Our Case Number: ABP-318446-23

Re: Proposed construction of Coumnagappul Wind Farm consisting of 10 no. turbines and associated infrastructure.
In the townlands of Coumnagappul, Carrigbrack, Knockavanniamountain, Barricreemountain Upper and Glennaneanmountain, Skeehans, Lagg, Co. Waterford. (www.coumnagappulwindfarmSID.ie)

Our Ref: SID-WD-2023-037

Proposed Strategic Infrastructure Development (SID): construction and operation of a 10 turbine wind farm and associated site development works in the townlands of Bleantasourmountain, Carrigbrack, Clooncogaile, Coumnagappul, Glennaneanemountain, Kilkeany, Kilkeany Mountain, Knocavanniamountain and Reanadampaun Commons, Ballymacmague North, Ballymacmague South, Colligan More, Colliganwood, Eaglehill, Garryclone, Garryduff, Kilcooney, Killadangan, Knockacaharna, Knockboy, Lackandarra Upper and Tinalira

Releve Survey Report

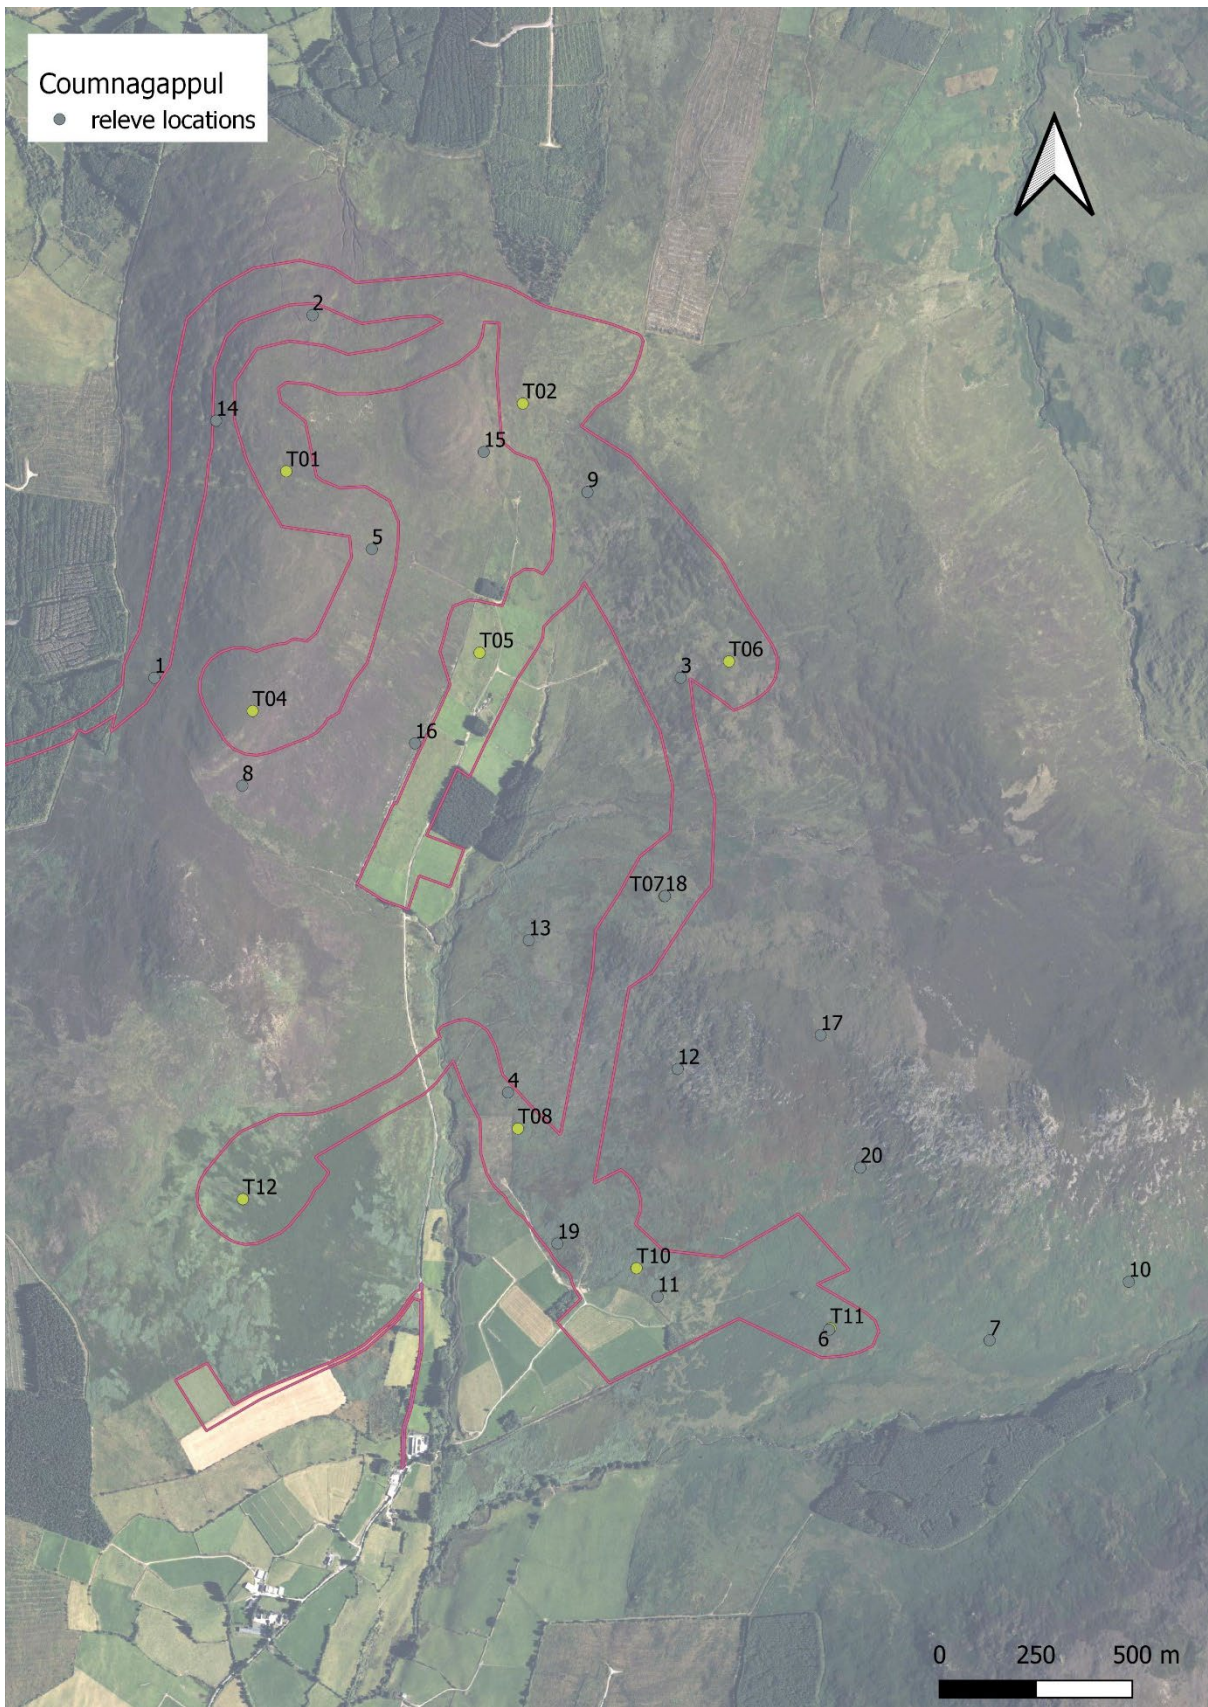
The vegetation assessment prepared to support the application did record one sample of what they consider Annex I quality (Relevé 1) and a greater number of sample points may have presented a different overall picture. The assessment effectively carried out 13 relevés

across 110ha (51.8ha of dry heath and 58ha of wet heath. The Guidelines for a national survey and conservation assessment of upland vegetation and habitats in Ireland² (Table 5, p48) recommends 12 monitoring stops for each habitat in areas 50-100ha, therefore this Department considers at least 24 monitoring points would have been more appropriate. The assessment concluded for relevés 3 and 9 that there were no links to Annex 1 even though they were not surveyed due to burning at the time of survey; inappropriate burning as already outlined can lead to degradation of habitat, but planned burning can also be used as a tool to manage Annex 1 heath, the fact that these relevés were on fire does not exclude them from being Annex 1 habitat. We disagree with conclusions relating to several of the relevé that were carried out, for example the conclusion of no link to Annex I habitat due to the absence of *Erica tetralix*, when *E. tetralix* occurs widely but didn't fall within the selected 2x2m sample points, fails to see the habitat in context. We also disagree with similar conclusions in relation to the percentage of bare ground or the presence of negative indicator species without seeing the context of surrounding habitat.
